WEST SUSSEX COUNTY COUNCIL CONSULTATION

TO:	Arun District Council FAO: Raymond Cole
FROM:	Stephen Gee WSCC - Highways Authority
DATE:	16 December 2020
LOCATION:	Land south of Barnham Station Barnham
SUBJECT:	BN/142/20/OUT Outline planning application with all matters reserved, other than principal means of access, for up to 200 No. dwellings, with access taken from Marshall Close, associated infrastructure & landscaping & demolition of existing buildings. This application is a Departure from the Development Plan, may affect the setting of listed buildings, may affect the Church Lane, Barnham Conservation Area & affects a Public Right of Way.
DATE OF SITE VISIT:	
RECOMMENDATION:	More Information
S106 CONTRIBUTION TOTAL:

FIGURE 48. Plan showing the main access to the site from Marshall Close (i-transport)

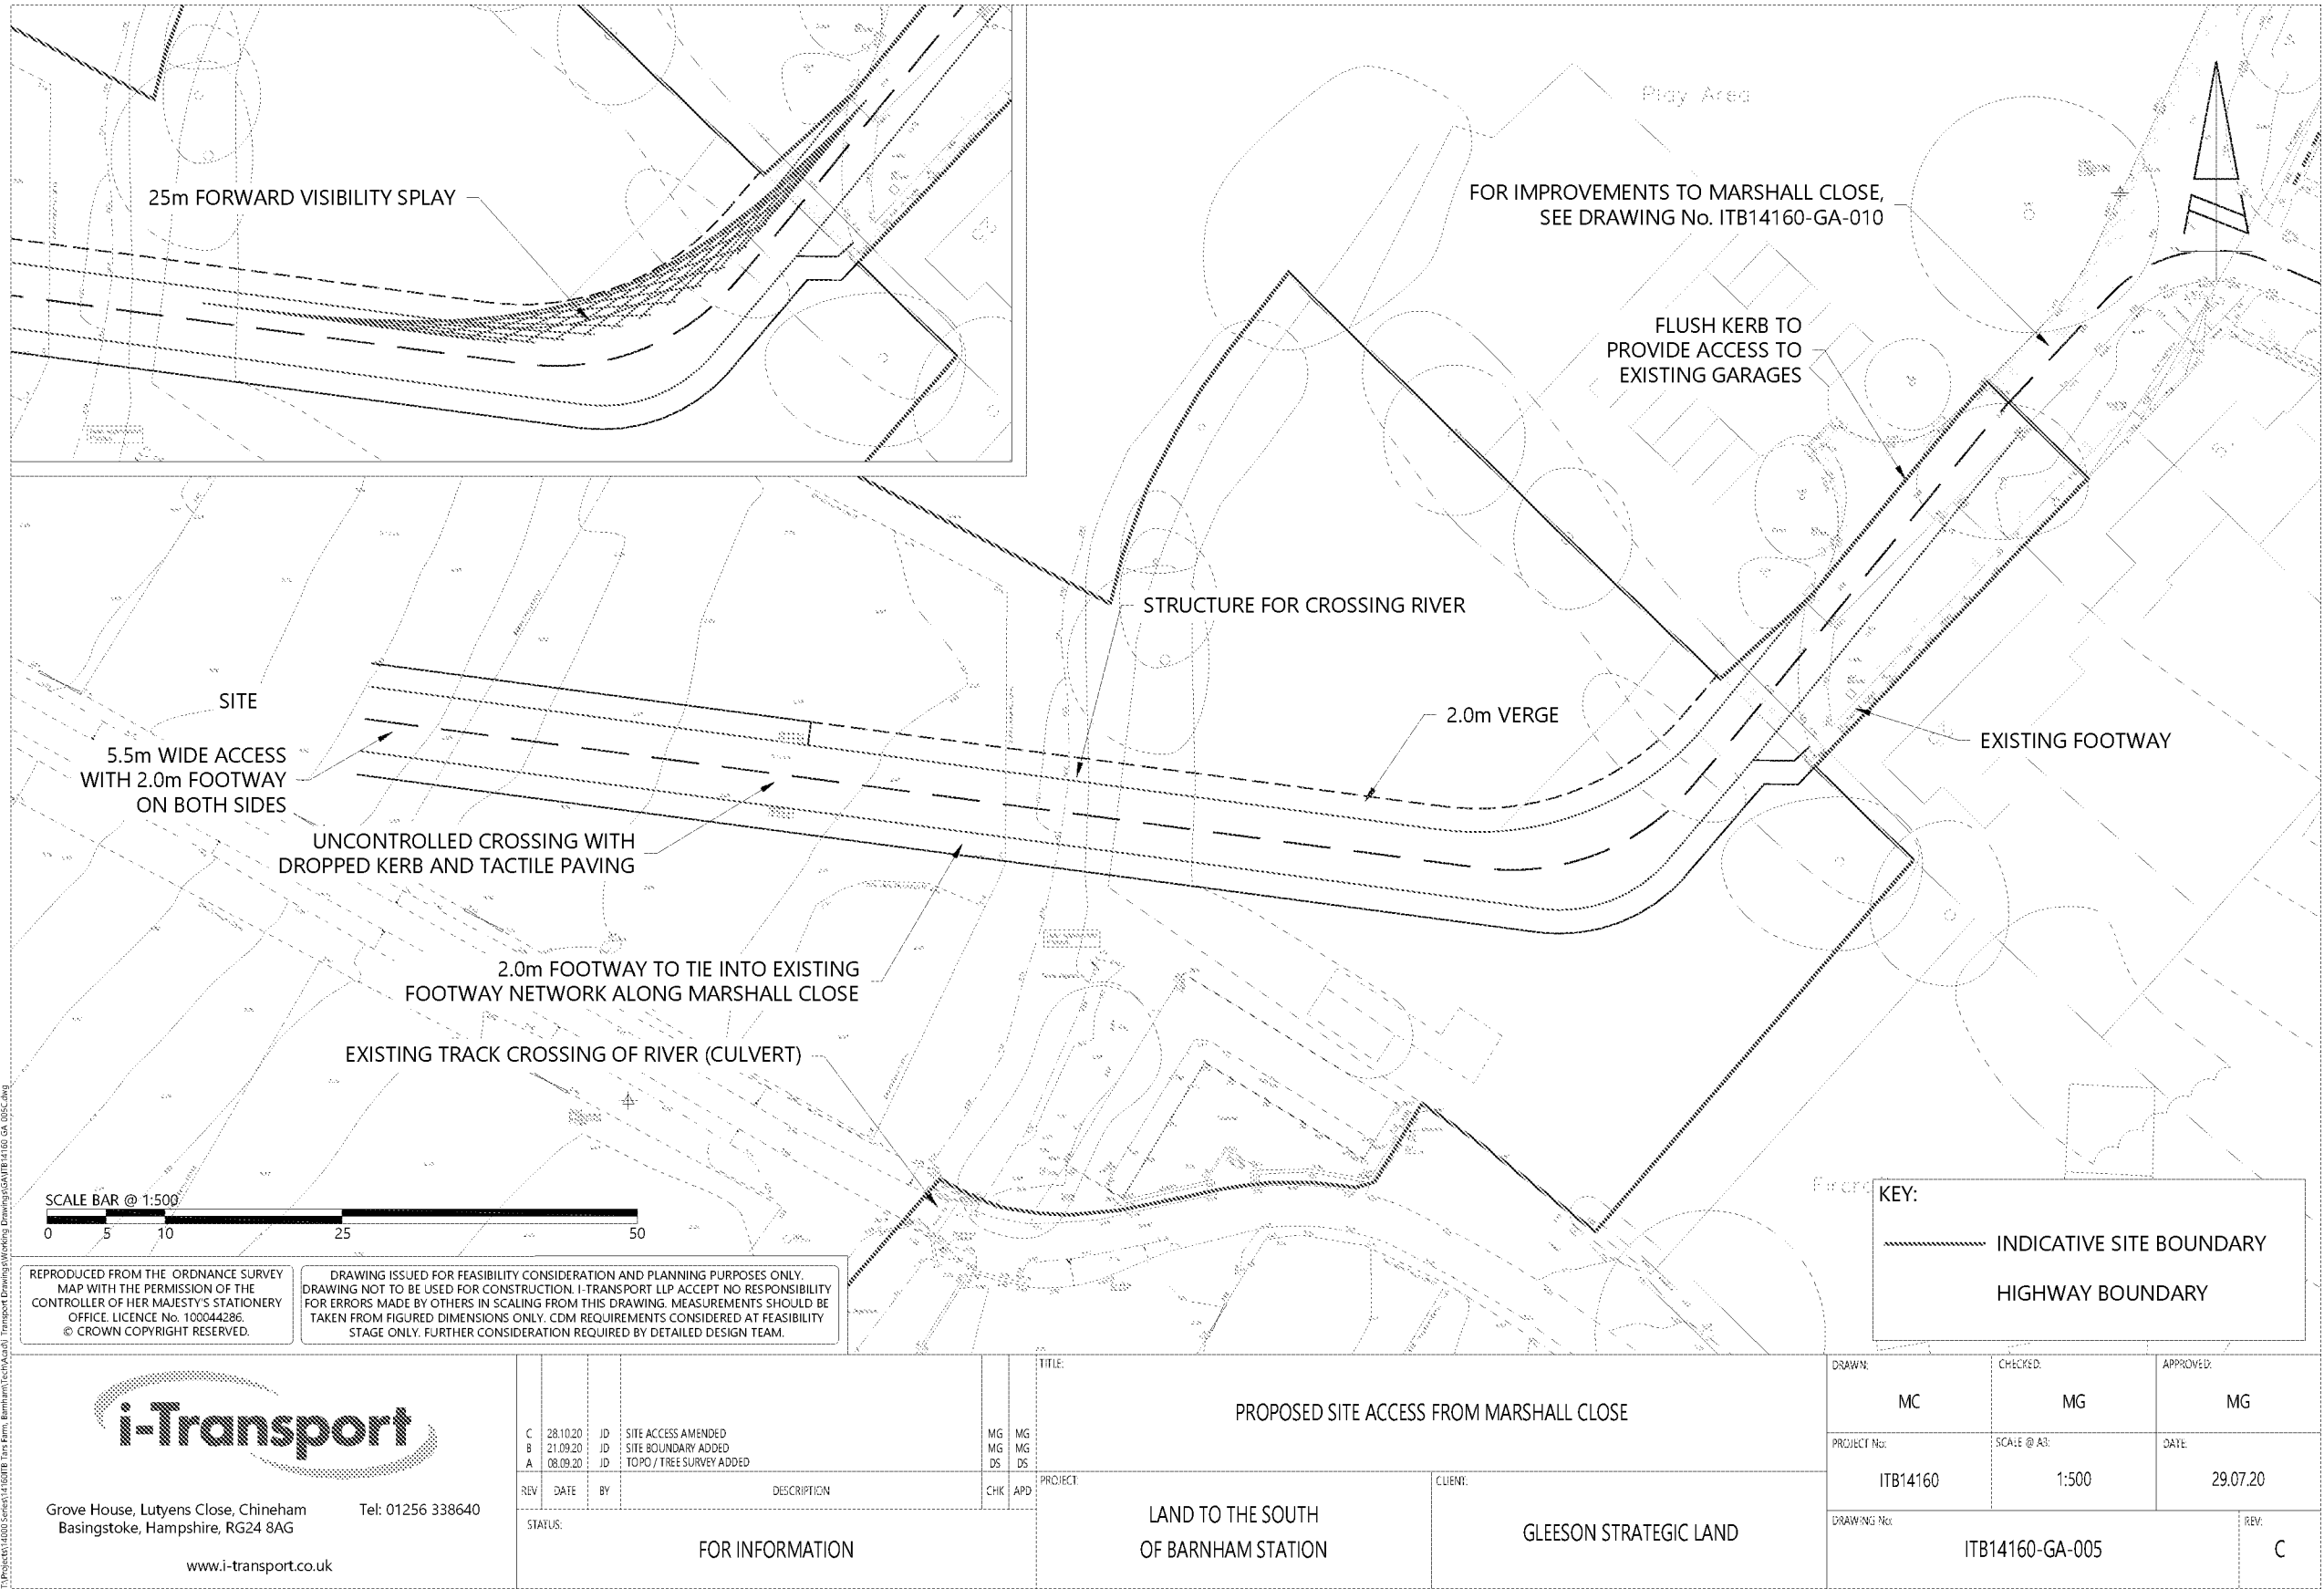
The site is to be accessed via an extension of Marshall Close. The access road is to measure 5.5m with a 2m wide pedestrian route into the site. Once within site 2m footways would be provided on both sides.

No stage 1 RSA has been provided for the proposals and should be done so.

FIGURE 49. Plan showing proposed highway improvements to Marshall Close (i-transport)

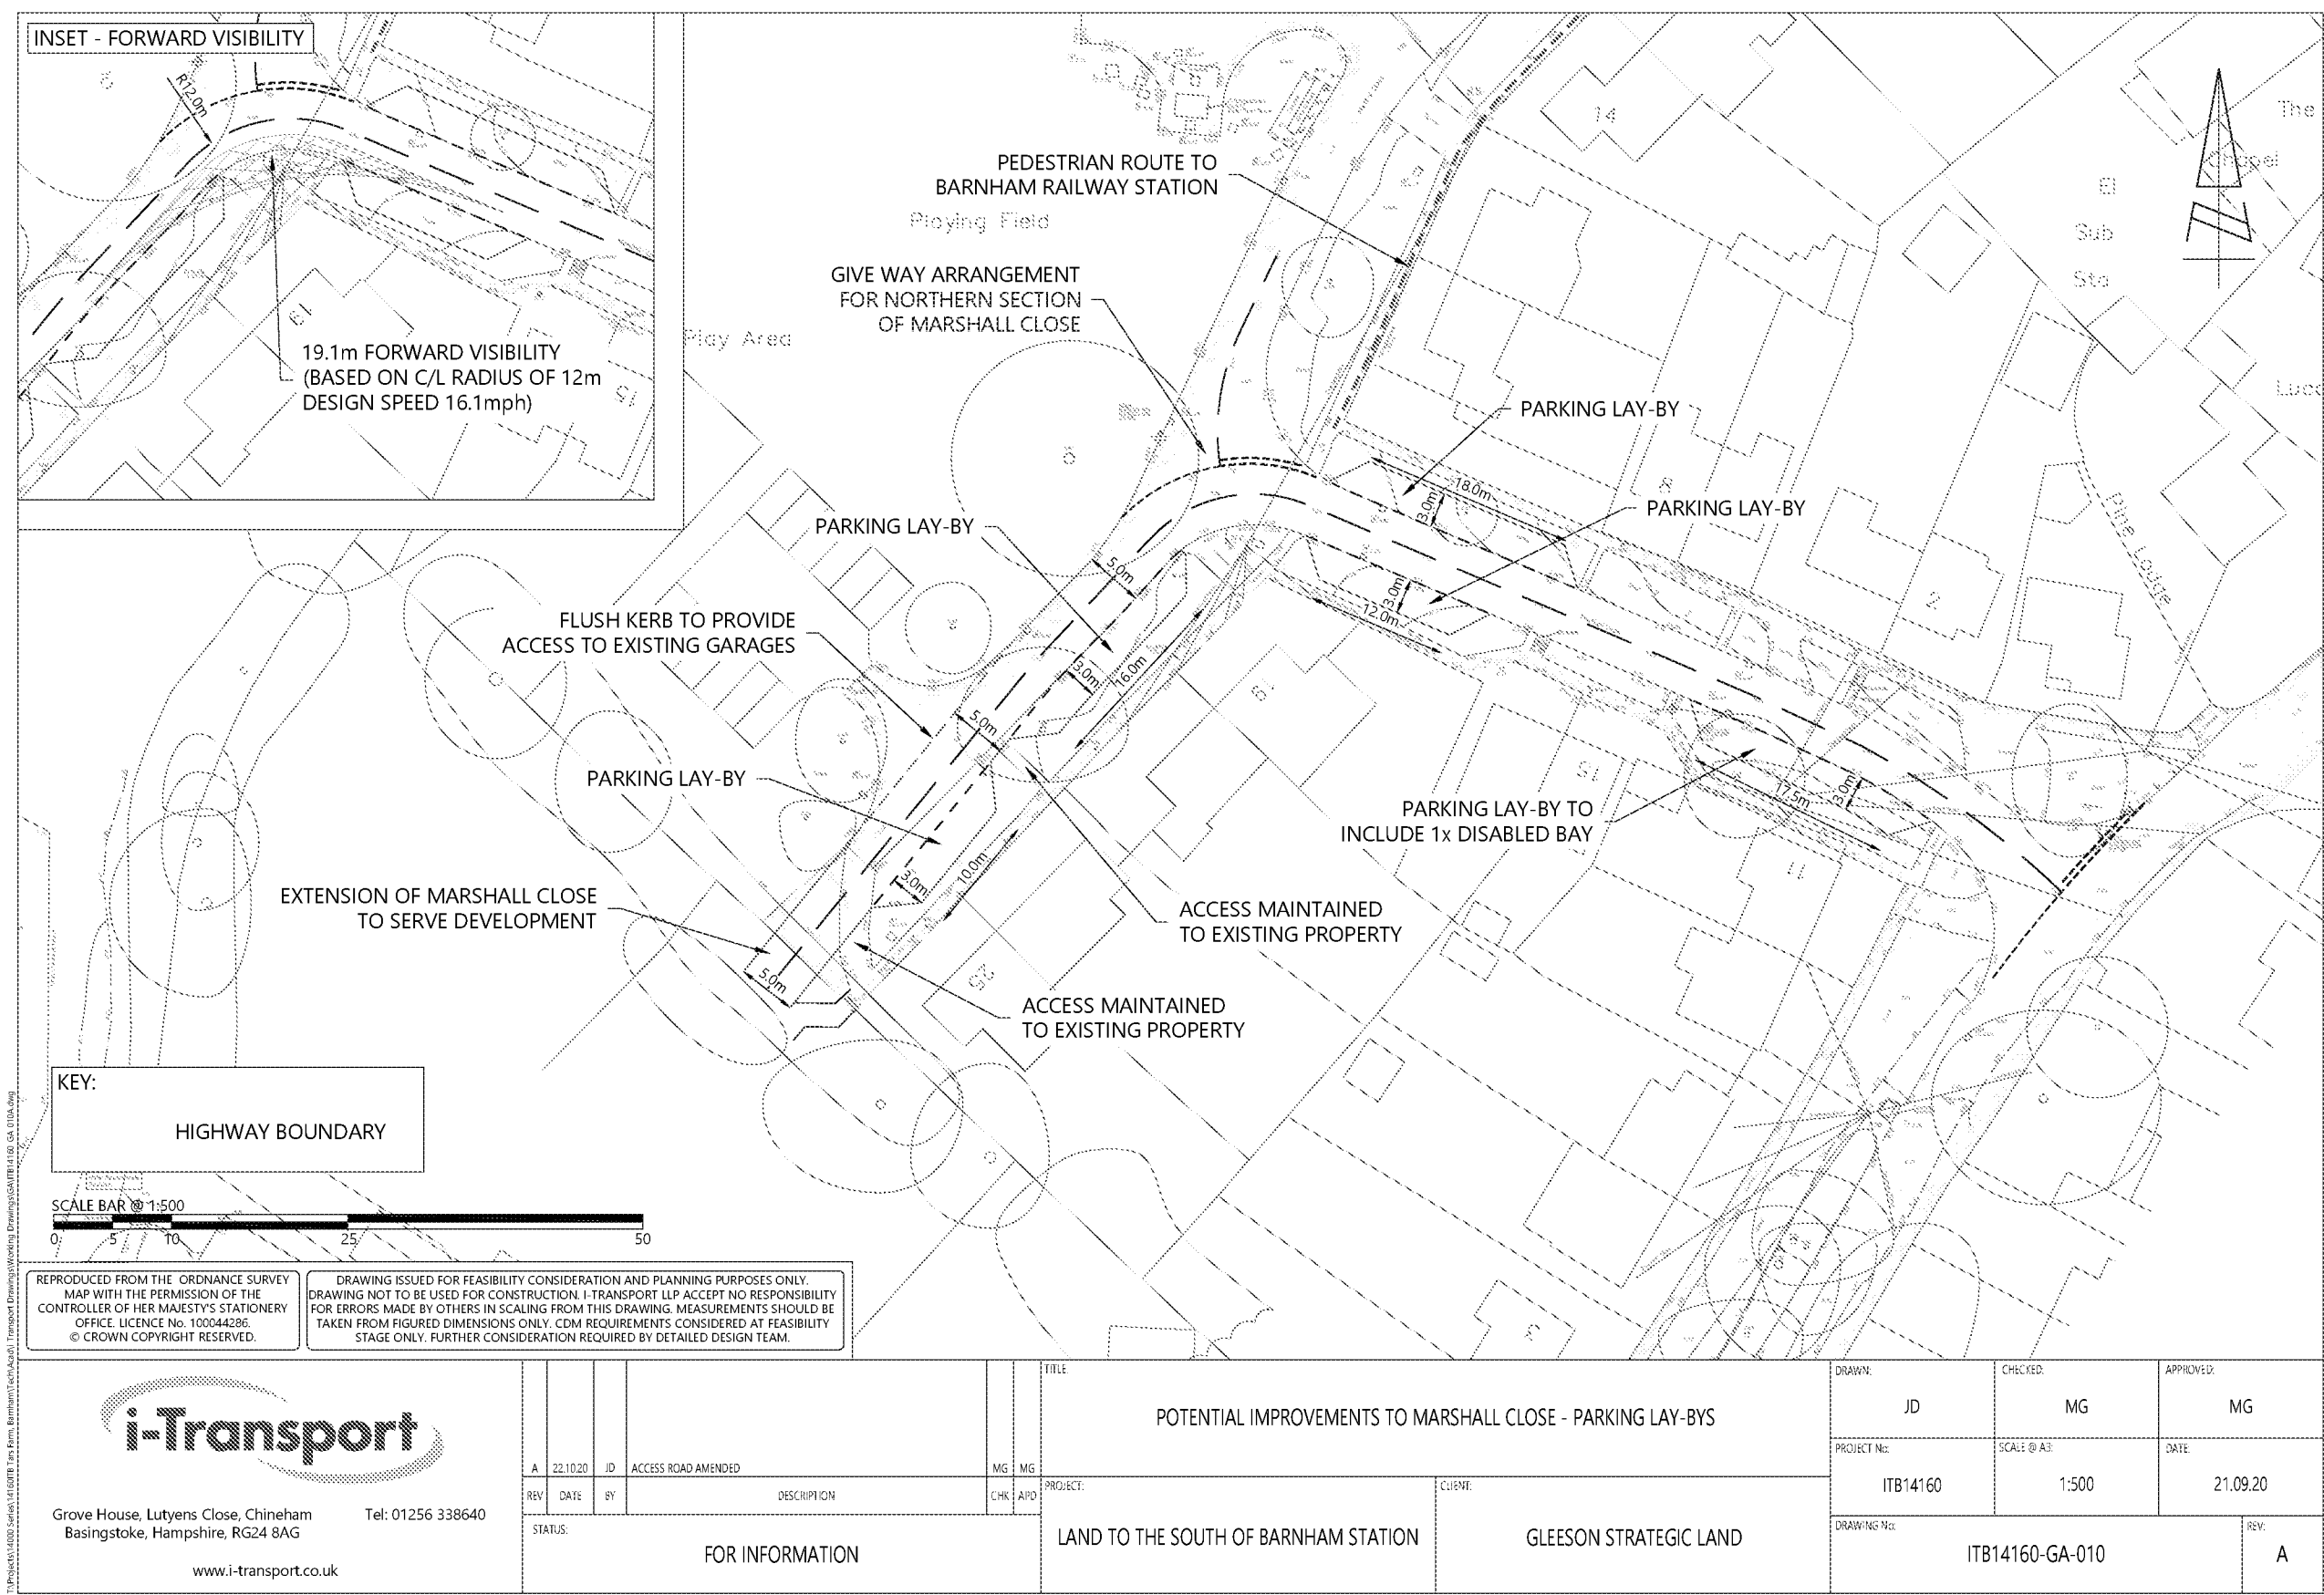
Marshall Close is currently subject to on street parking and as such off-carriageway laybys are proposed which would accommodate 12-15 vehicles. The remaining width of 5m would be sufficient for a large vehicle to pass a car.

Swept path analysis as been provided and shows 2 cars can pass along Marshall Close, whilst a refuge vehicle would not be able to pass a car around the bend this would be an infrequent movement and forward visibility of 19.1m is achievable commensurate to a 16mph design speed.

Following consultation with the WSCC fire and rescue access manager no emergency access is required provided a 3.7m clear width can be provided along Marshall Close to which the parking bays would allow a fire tender to pass.
